## Department of Transportation

Region 2 Permits

SH 024G/MP 336.11 (R-A)  
El Paso County

RE: 13625 Noah Abel Pt - MC3 Business Event Center  
AL2326

Conceptual Site Plan

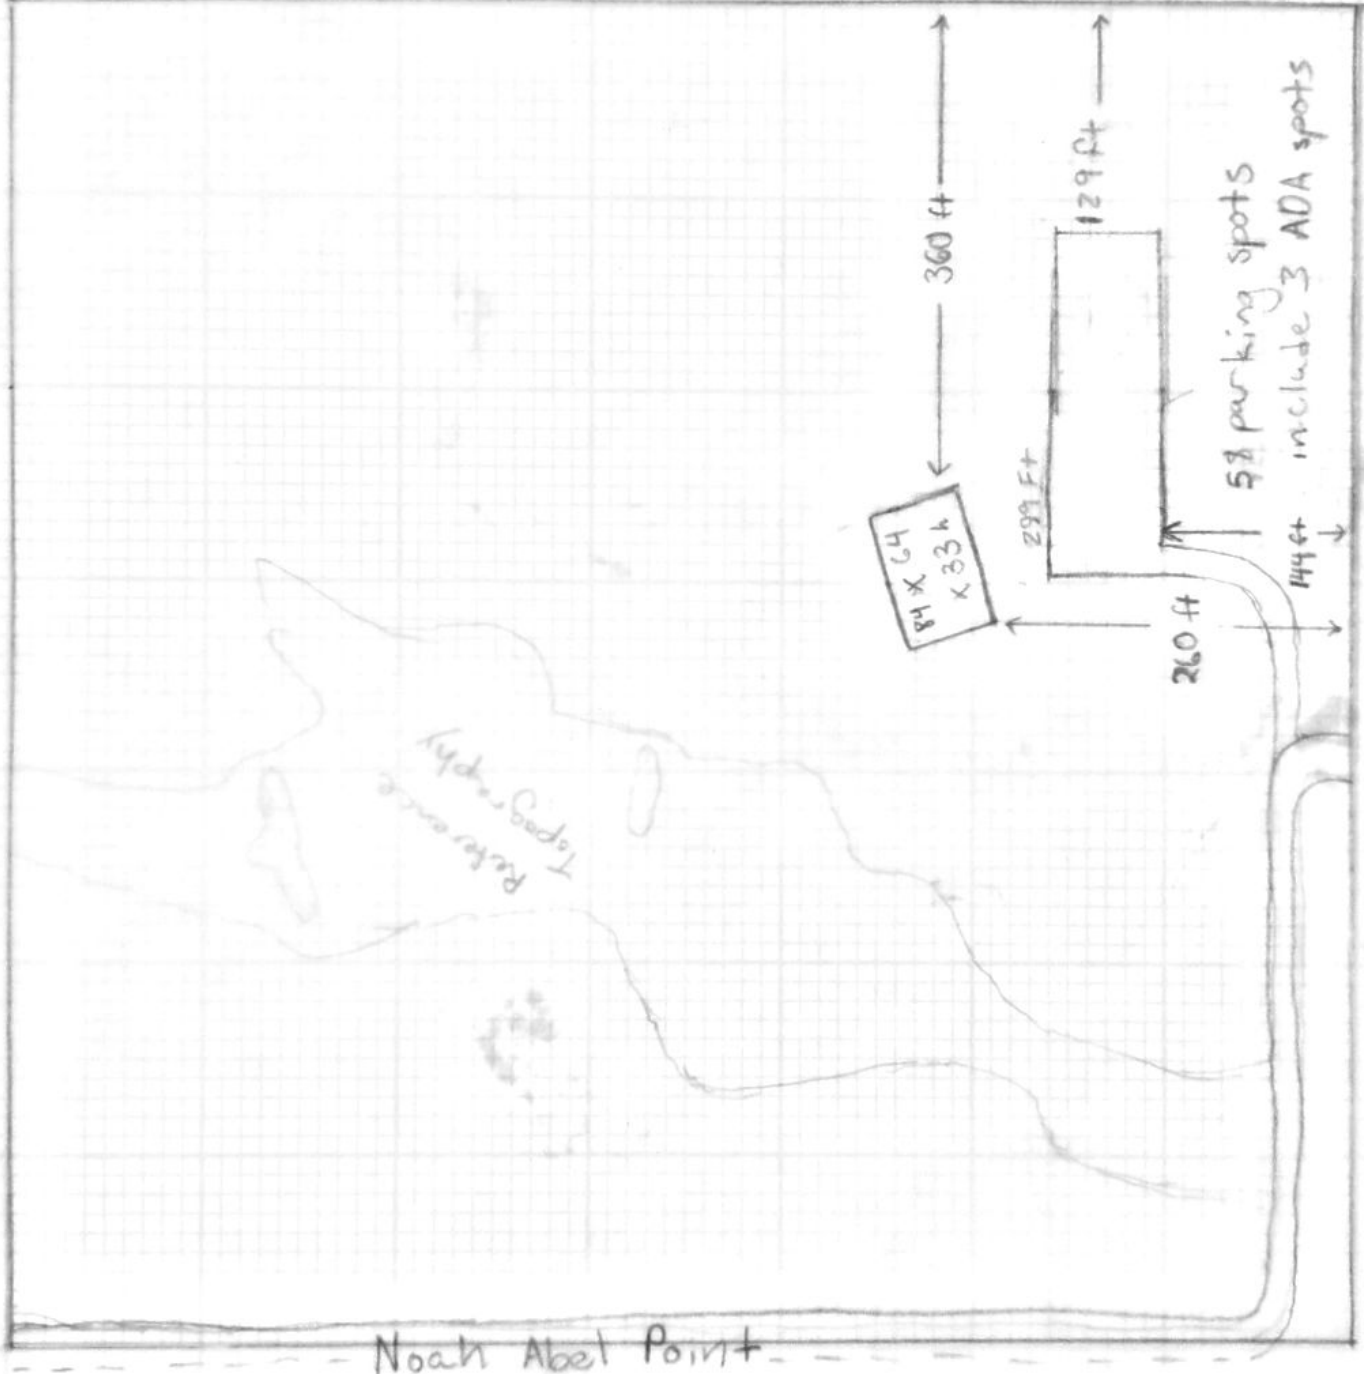
- The Trip Generation Memorandum is acceptable as submitted.
- Project peak hour entering traffic triggers the need for the left turn lane for eastbound entering traffic.
  - The deceleration lane is required to be constructed at 840' (decel length + storage).
- For the project to proceed without constructing the deceleration the number of guest would have to be reduced to **20**.

- The State Highway Access Code requires an access permit if the proposed vehicle volumes increase by 20 percent or more, the development is adjacent to the state highway, and/or significant changes in the use of the property are made which will affect access operation, traffic volume and/or vehicle type.
- There is a current access permit for this location (AP #217074) for four (4) single-family residences. A new access permit will be required of this development to document the change in use of the access and property as well as document the required left turn lane for eastbound entering traffic.
- CDOT suggests the access for egressing traffic exiting the development onto the private drive be moved further to the west. The access for ingressing traffic can remain where shown on the site plan. Only one access onto SH024 will be allowed.
